# WEST MAGNOLIA

SW1/4 SW1/4 SEC. 36, T. 30 N., R. 5 E., W.M.  
CITY OF MARYSVILLE, SNOHOMISH COUNTY, WASHINGTON (FILE NO. PA22-033)

PROJ. NO. 24027 SHEET 2 OF 4

PROJ. NO. 24027 SHEET 3 OF 4

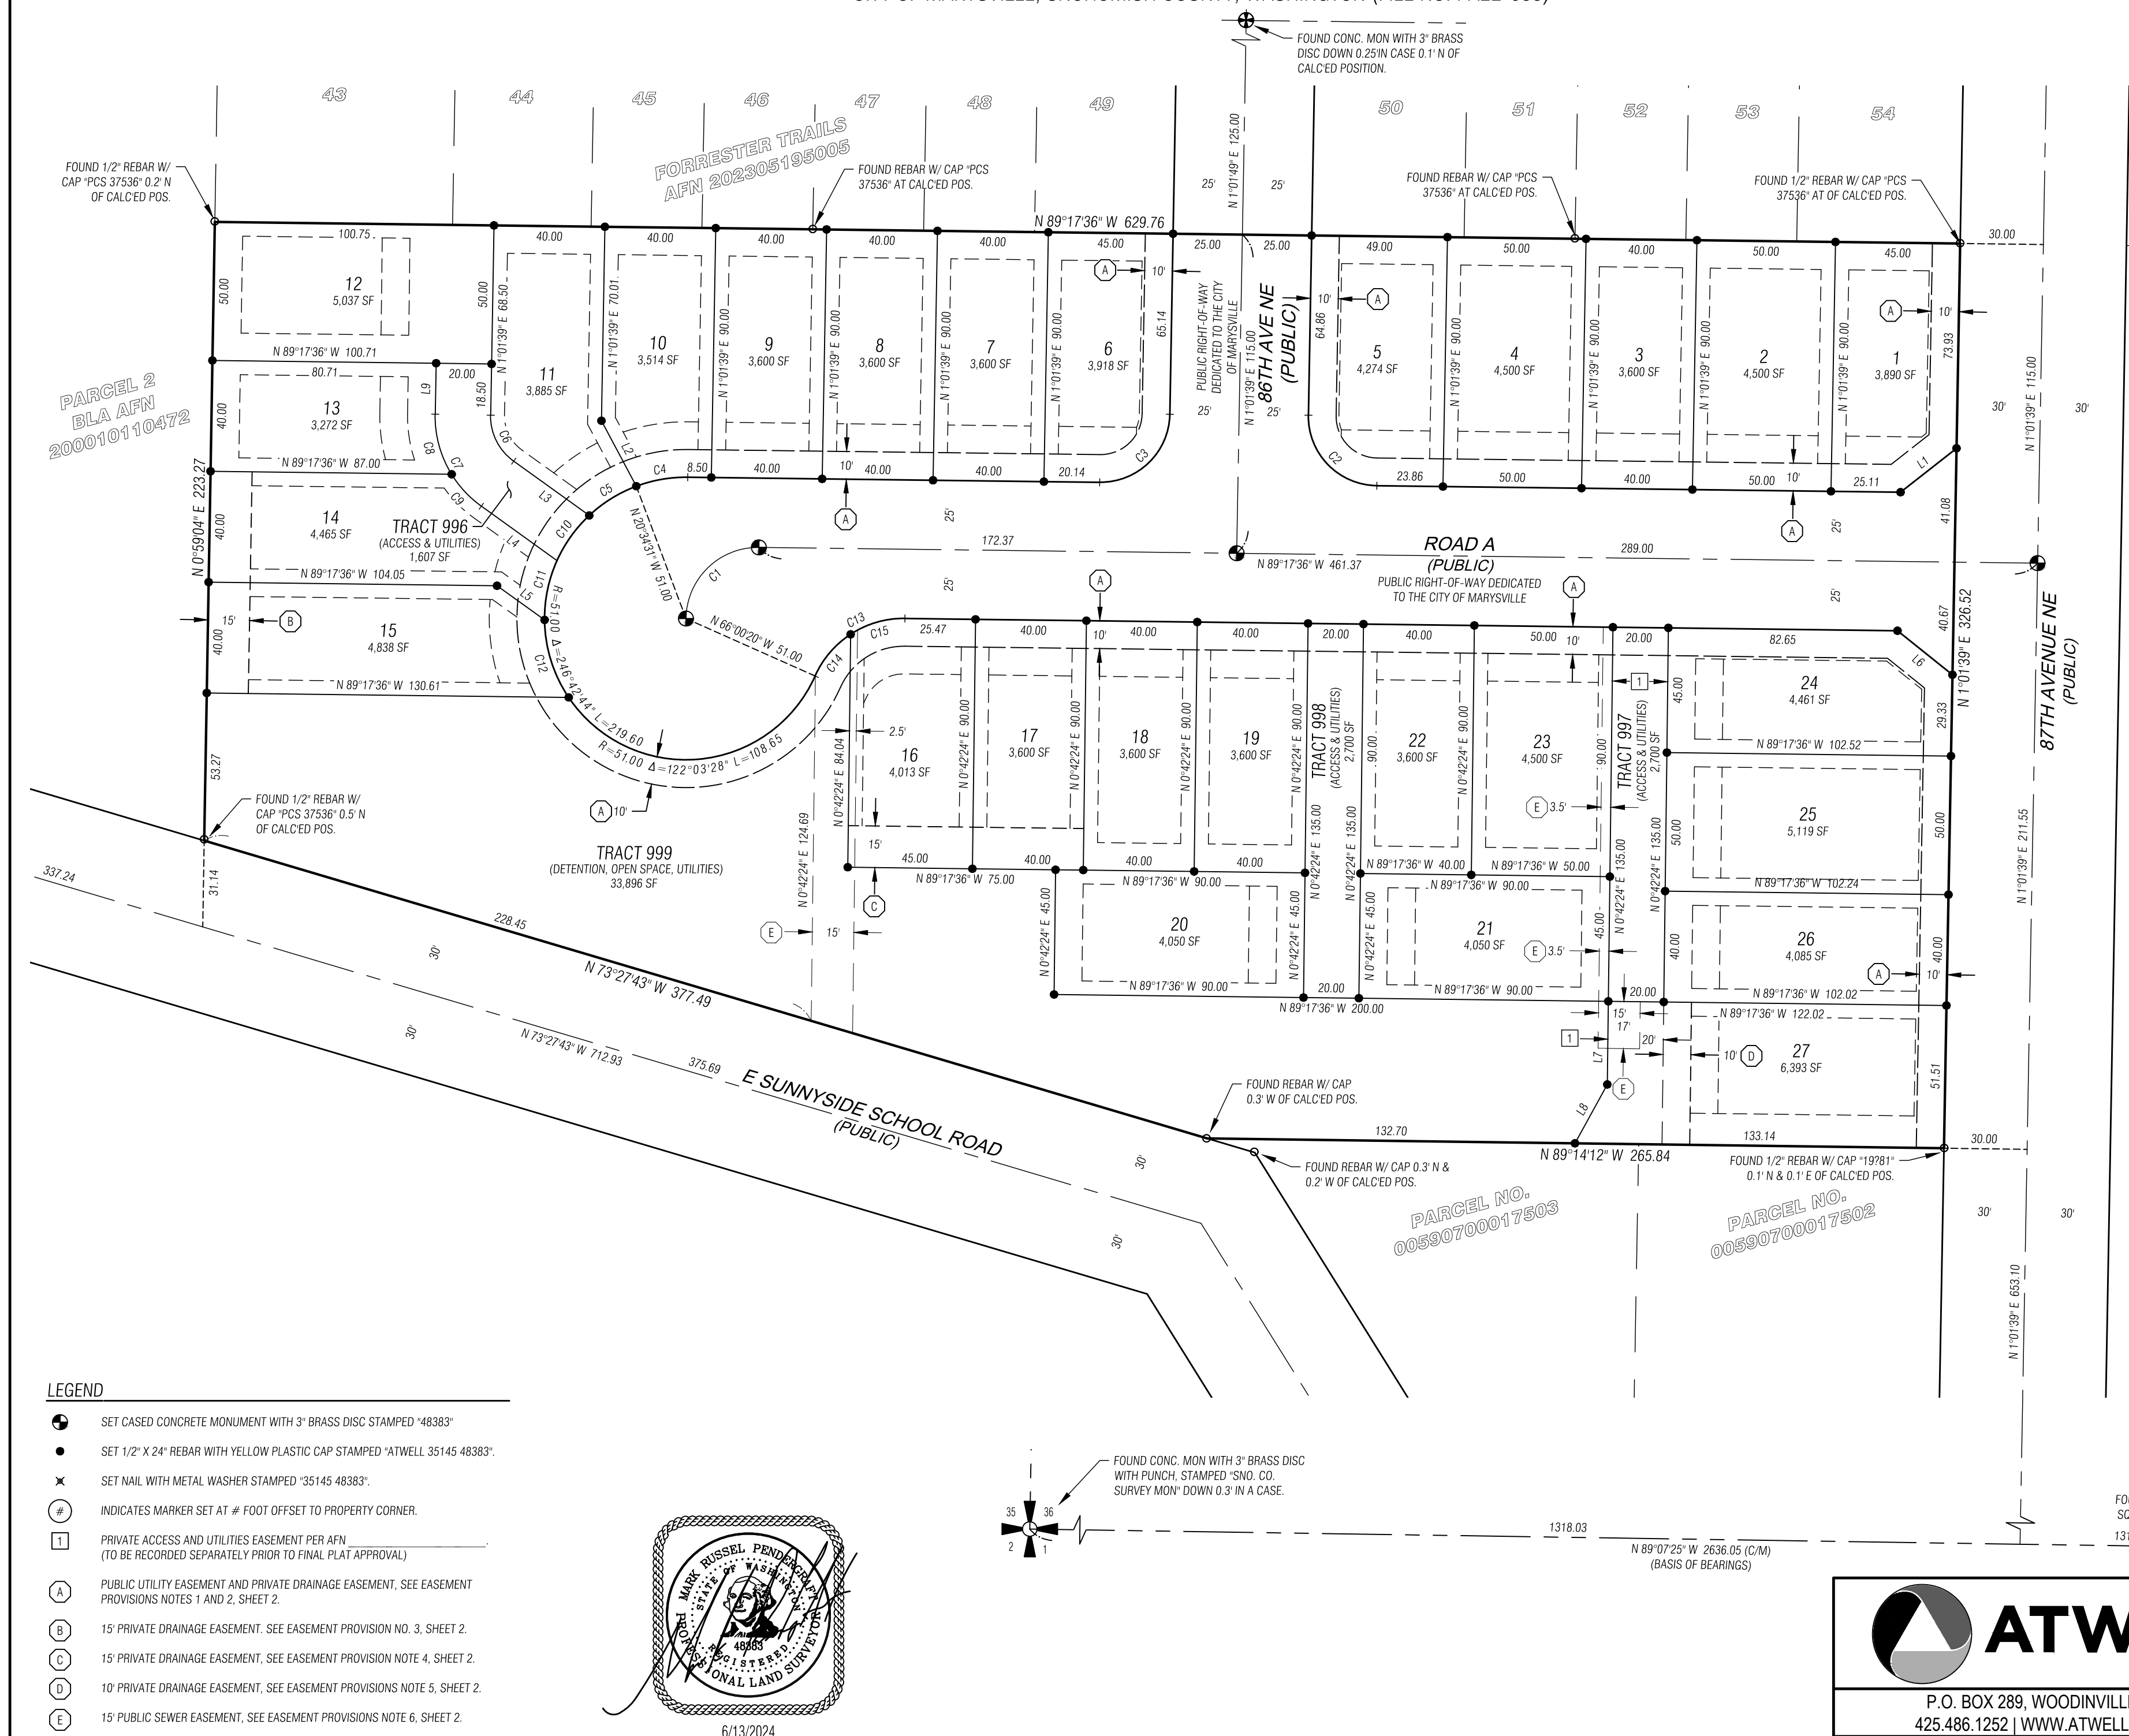
< Minimum lot size  
3,500  
adjusted lot

Need road name

should be curves not lines?

Updated road name

the curb returns are curves, the linework is shown this way on the prelim plat and i believe it was done to accommodate a larger walk behind the ADA ramps.
